Your ref: 3/2020/0586
Our ref: DC/20/3019
Date: 04-SEP-20

Location: Lodematic Ltd Primrose Works, Primrose Road, Clitheroe, BB7 1BS.

Proposal: Discharge of conditions 12 (SW drainage) and 13 (foul and surface water).

Further to our review of the submitted drainage document (ref C-0938, issue 1, dated 7/13/2020), United Utilities recommends that condition 12 is not discharged.

Title: PROPOSED
DRAINAGE
LAYOUT

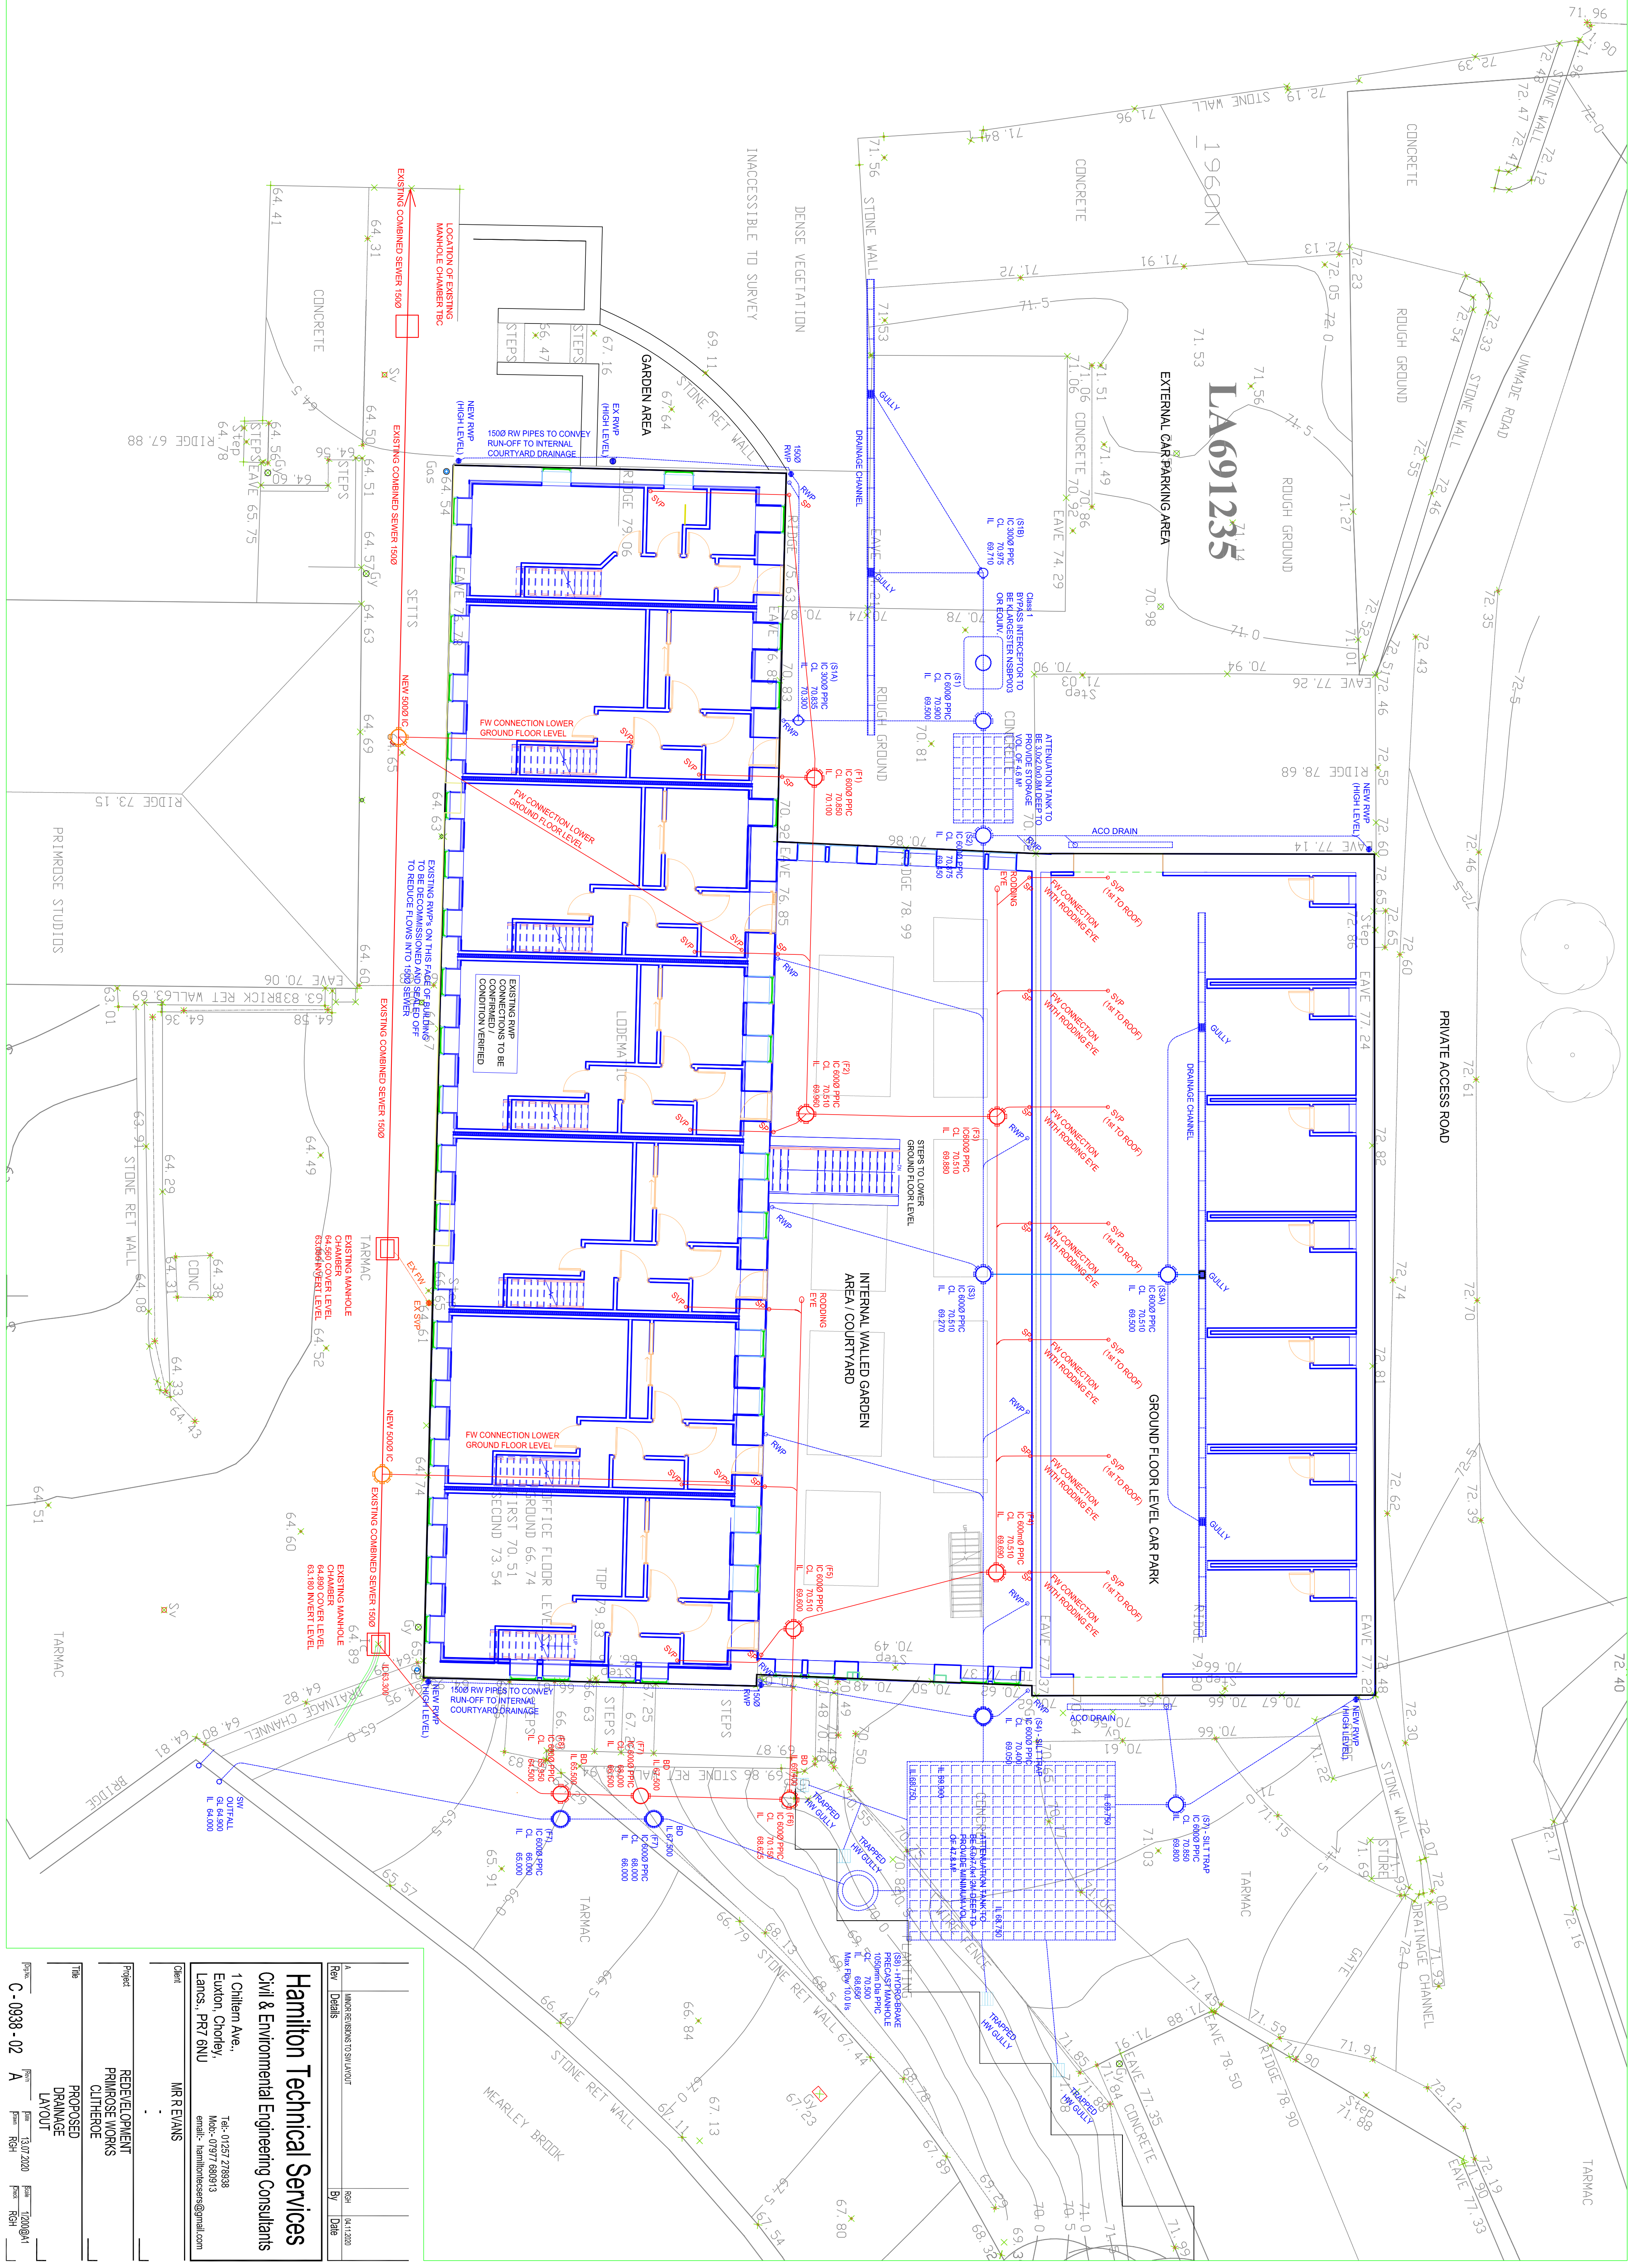
This is because we would expect surface water to discharge to nearby watercourse.
